Our Ref: A/50/15/PL

Demolition of Spinney & Burberry House & erection of 2 Storey hotel annexe with associated car parking
Premier Inn Spinney & Burberry House Roundstone Lane East Preston Angmering

Thank you for your internet comments made on 12th June 2015 which has been recorded as **'an objection'** with the comments as follows:

PROPOSED SITE PLAN

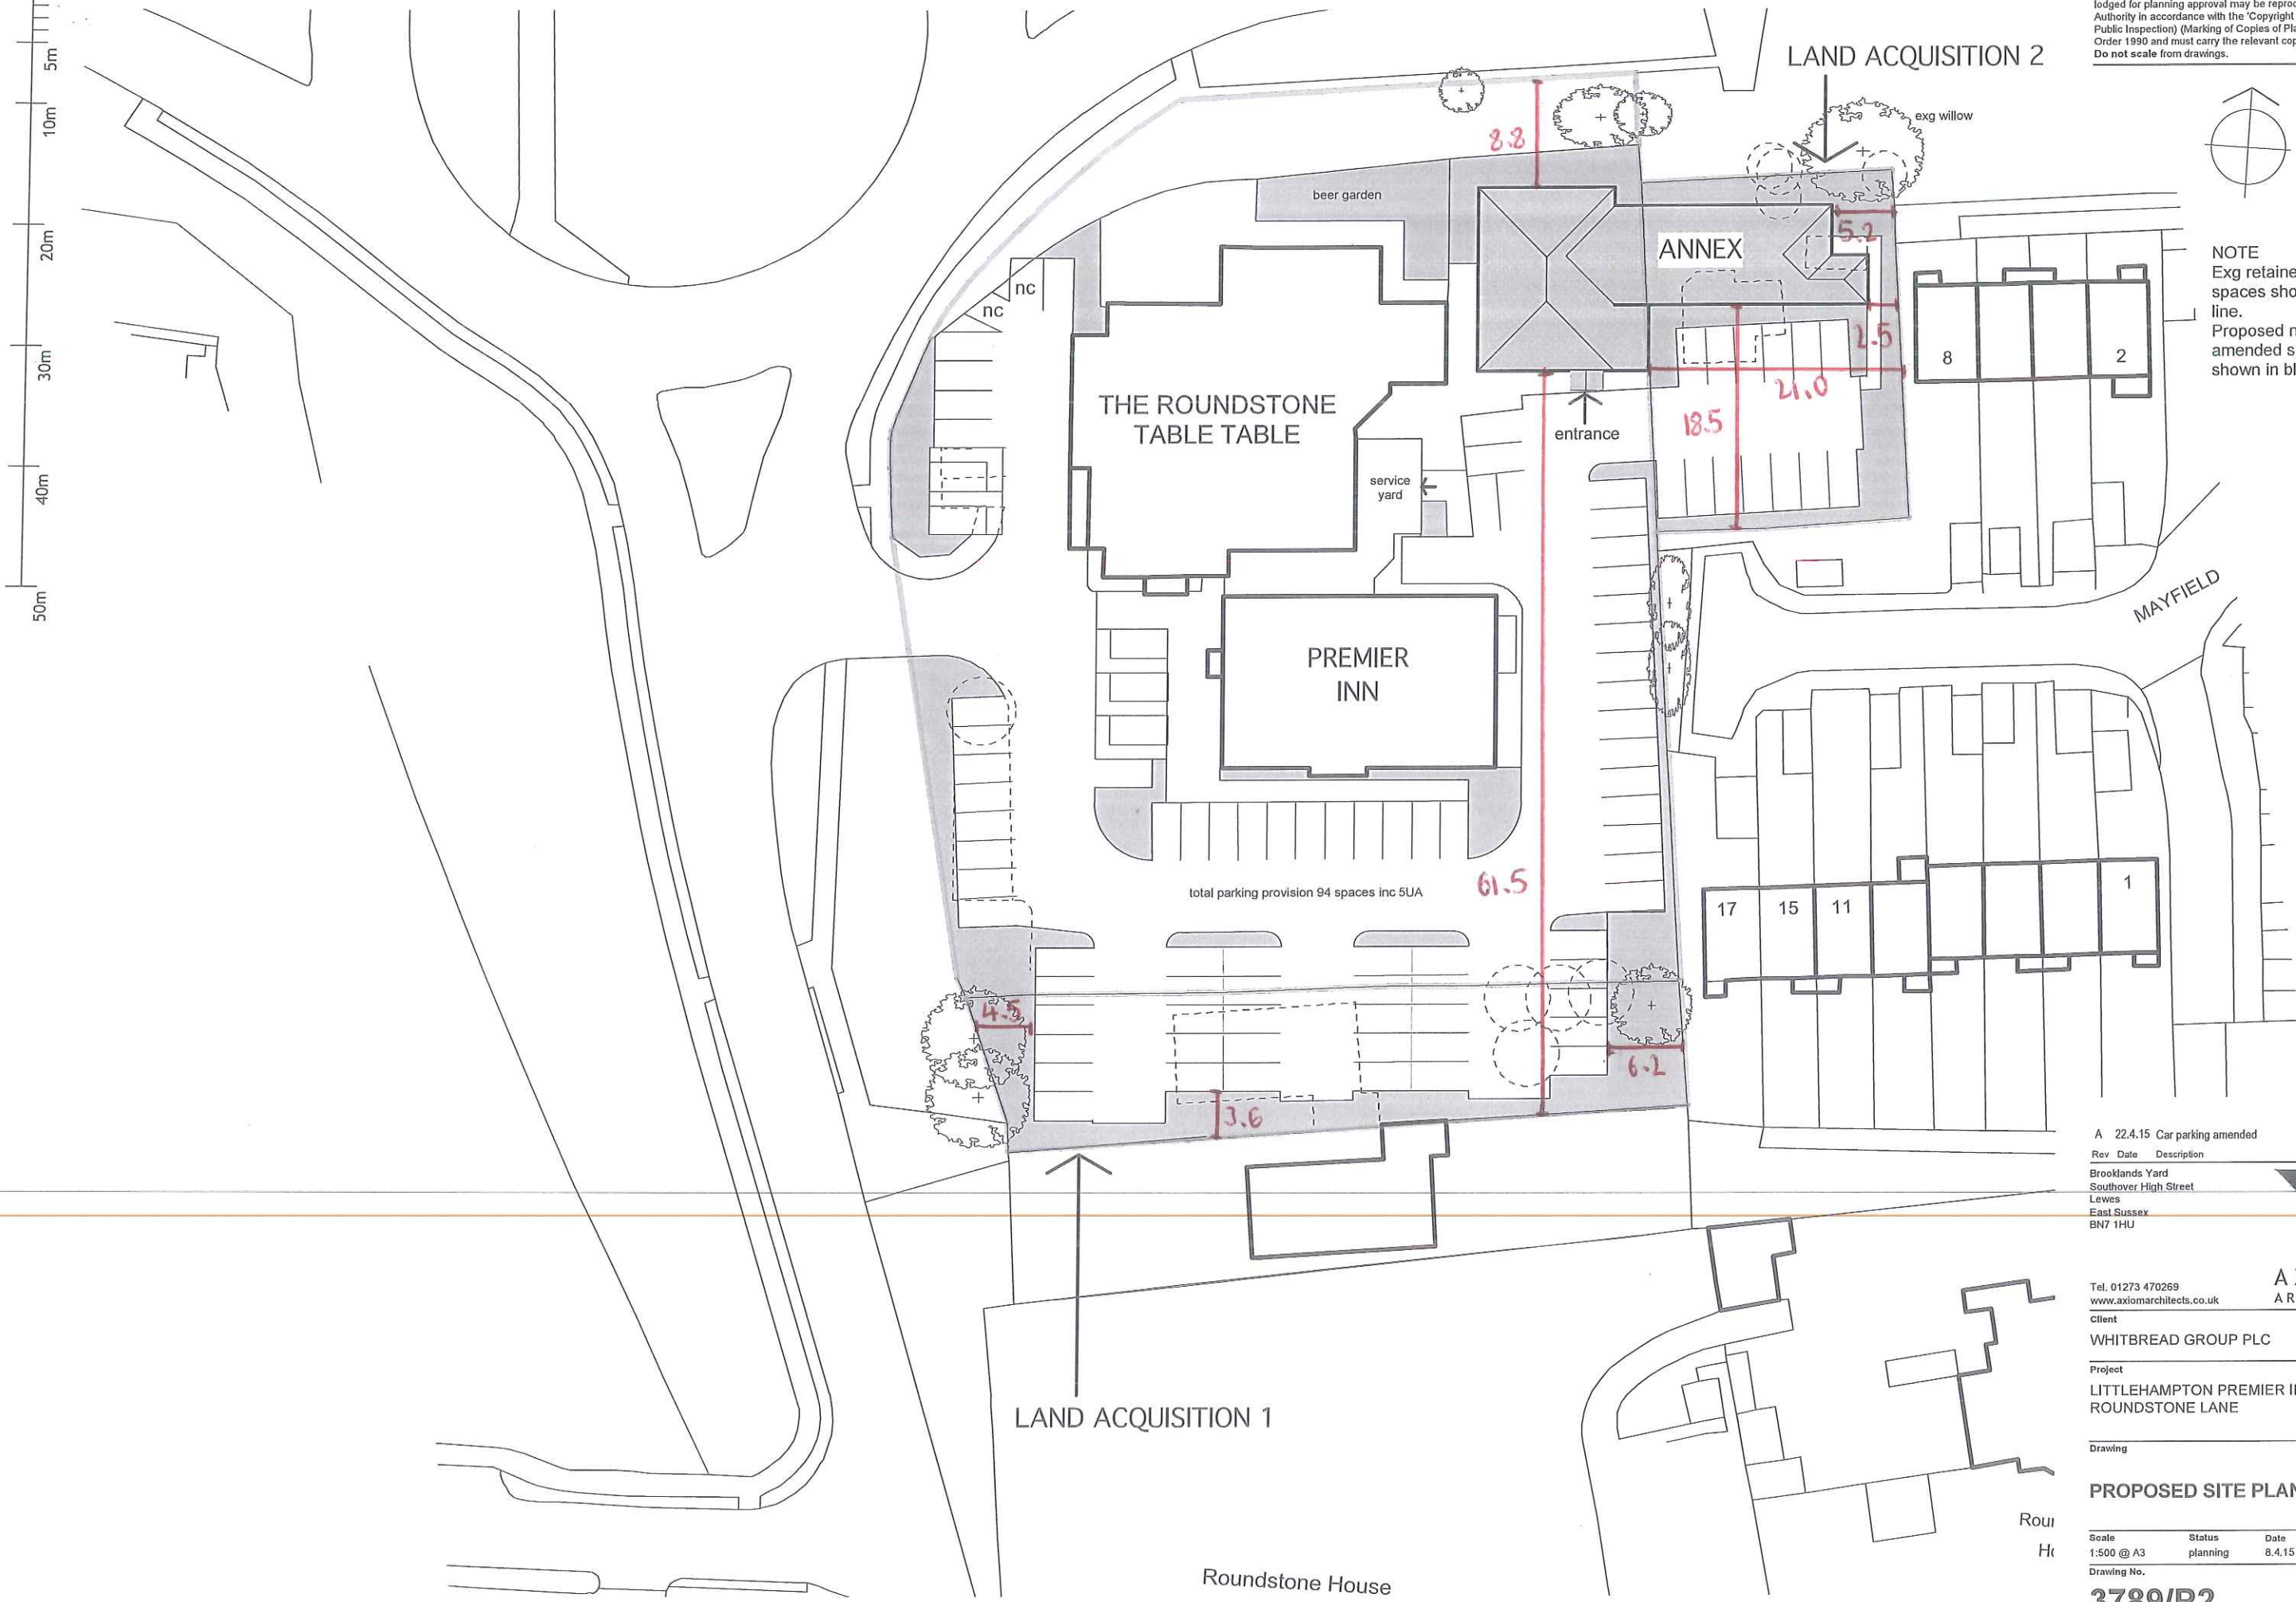
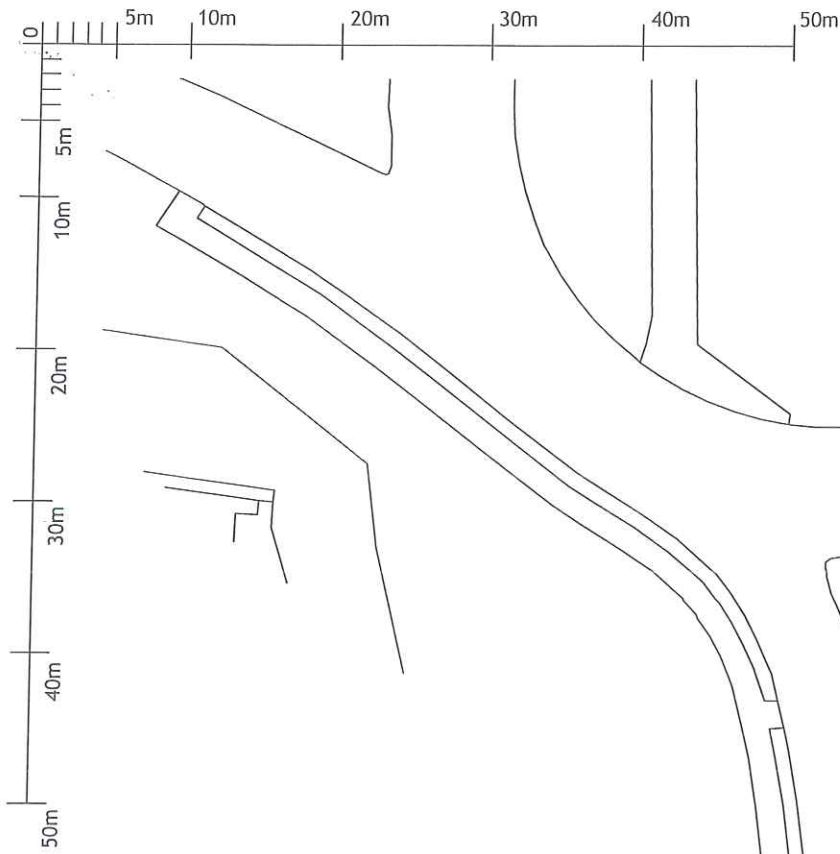
*Considered at Planning, Conservation & Development Committee Meeting, 10/06/2015.
More consideration needs to be given to the effect on neighbouring properties, in particular noise and the need for appropriate landscaping. Screening adjoining the neighbouring properties on the eastern and southern boundaries and the provision of dense hedging to reduce noise impact needs to be considered.*
